Your Ref:
Our Ref: FP/121/11/
Please ask for:
Mr J Smith

Two storey rear extension. Gable extension to front to include 2 balconies. Re-submission following FP/6/11/

Seacroft Outram Road Felpham Bognor Regis

Item ref	Quantity	Title/Name, designation, material, dimension etc			Article No./Reference
Designed by	Checked by	Approved by - date	File name	Date	Scale
JD				Sept 2010	1:200

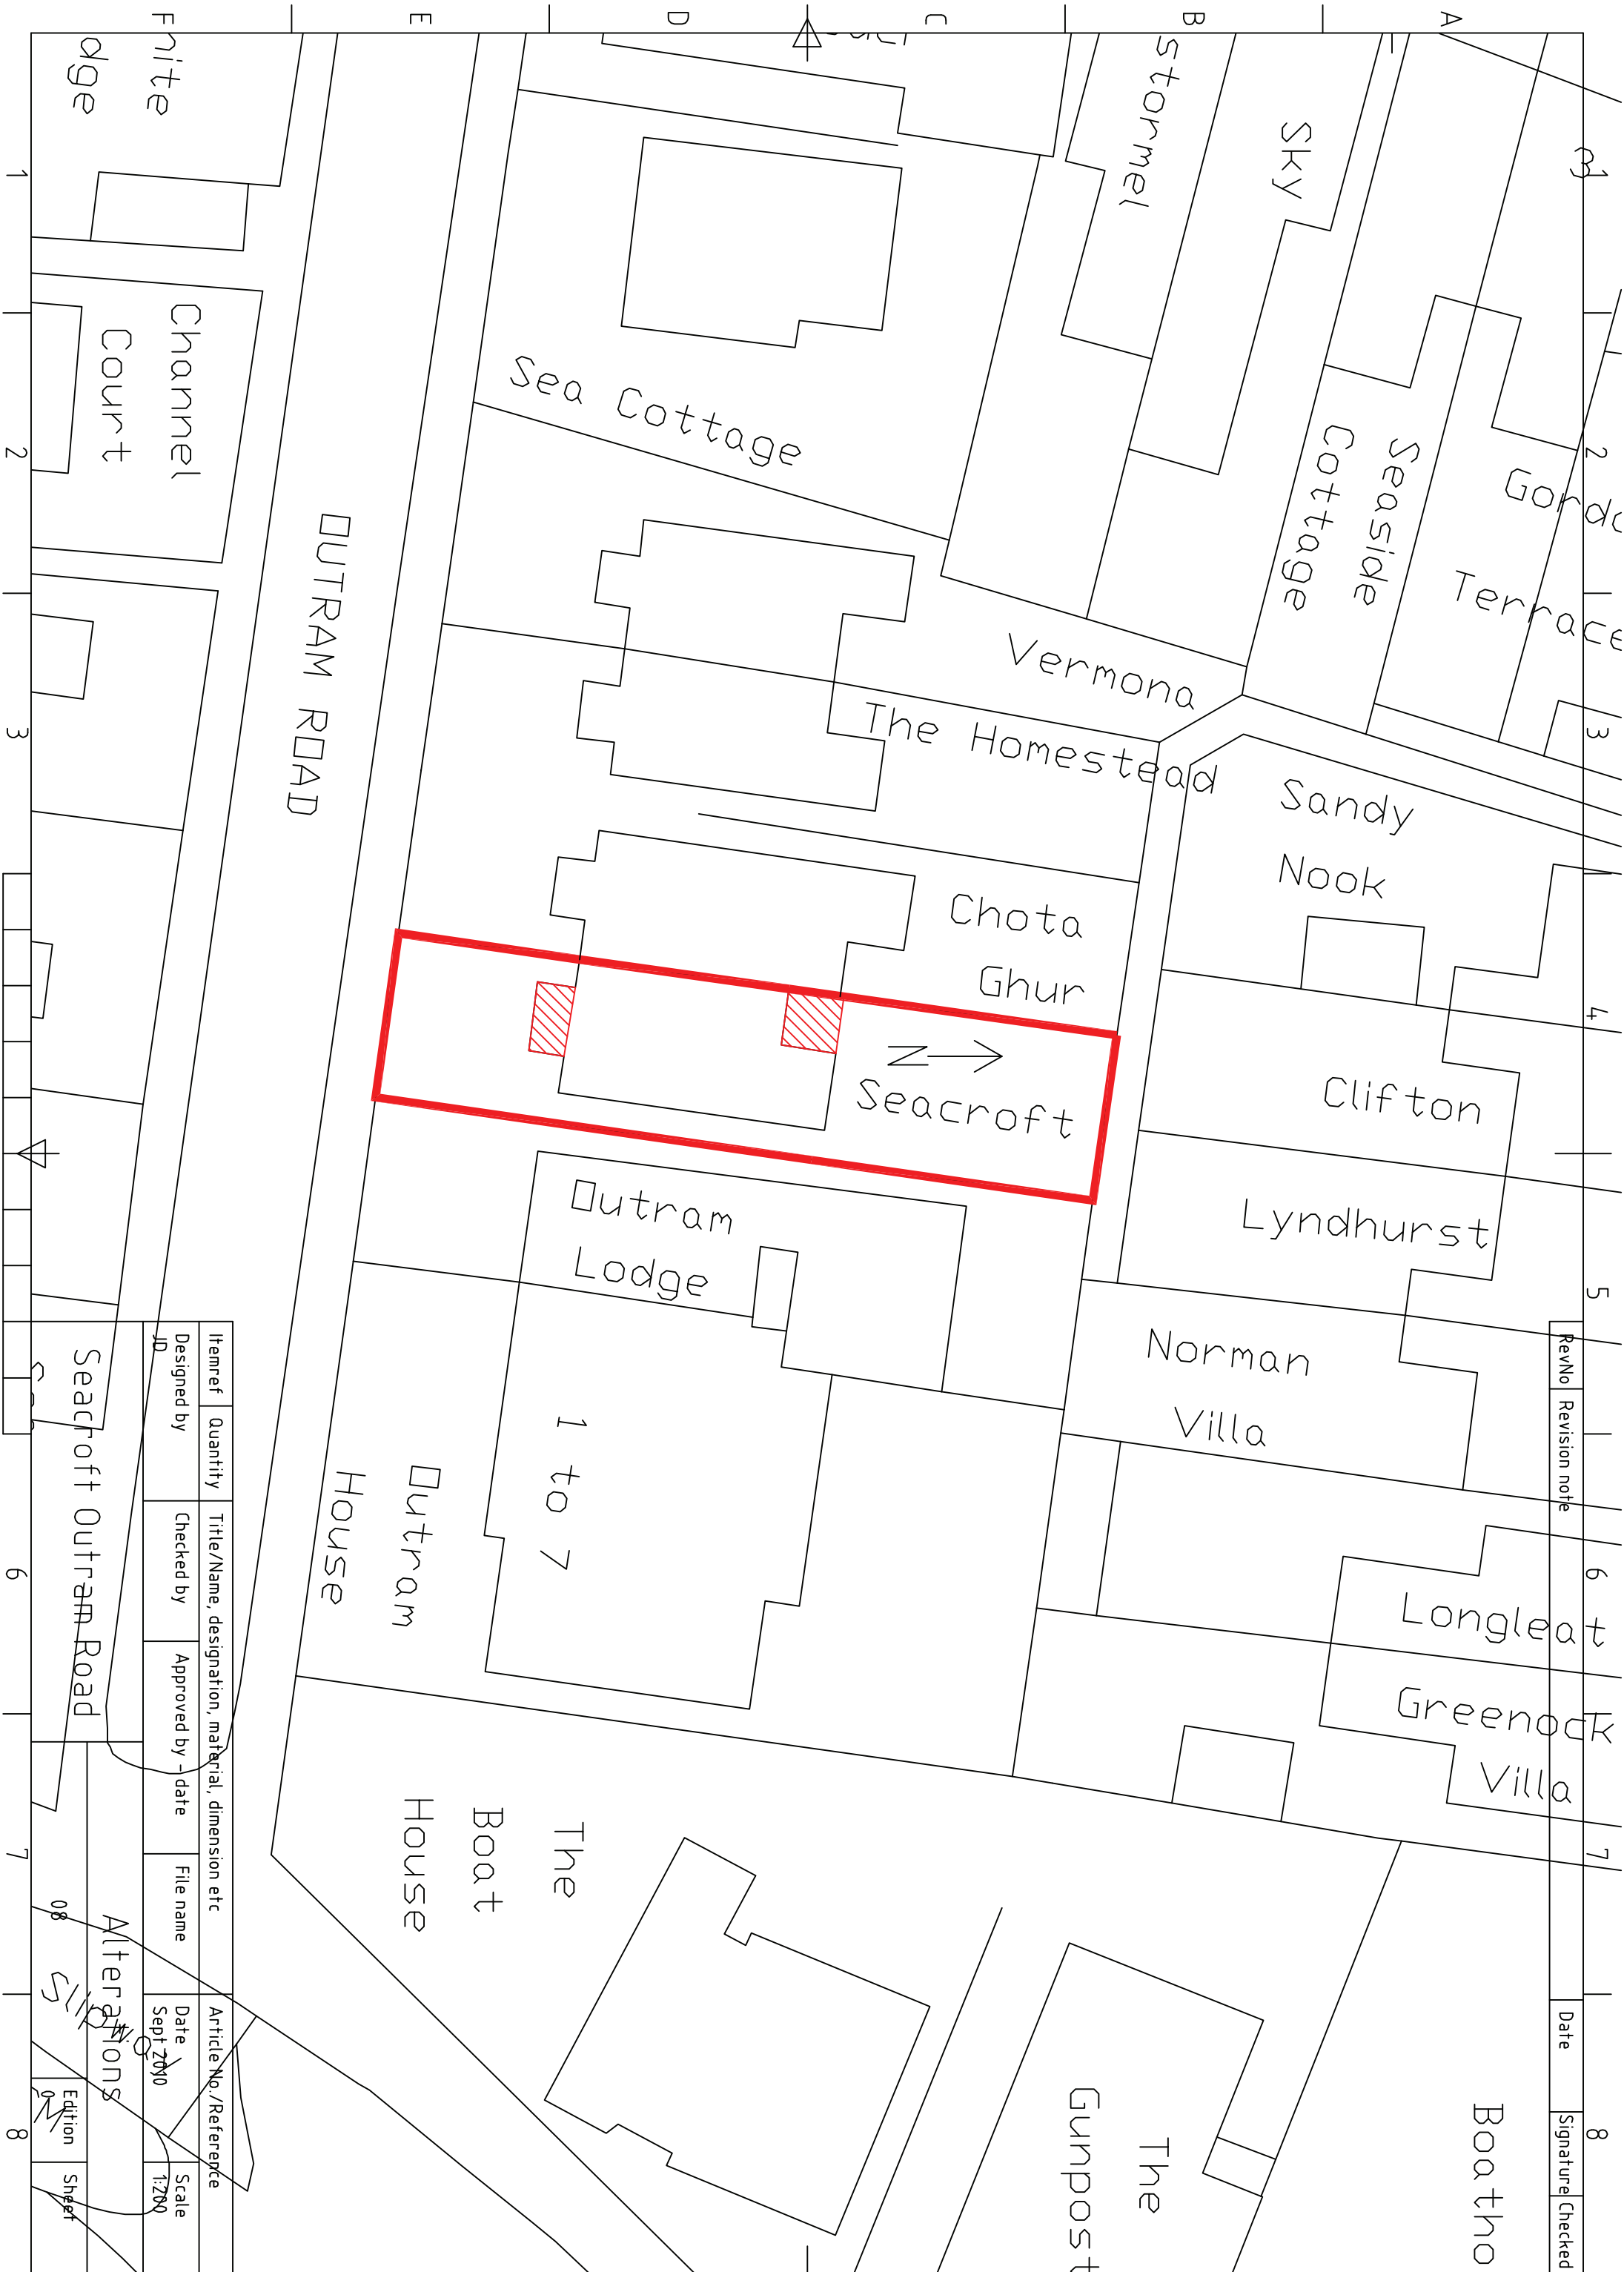
The site plan is misleading - at the rear of the property a cross hatched section is shown but it is unclear what this is.
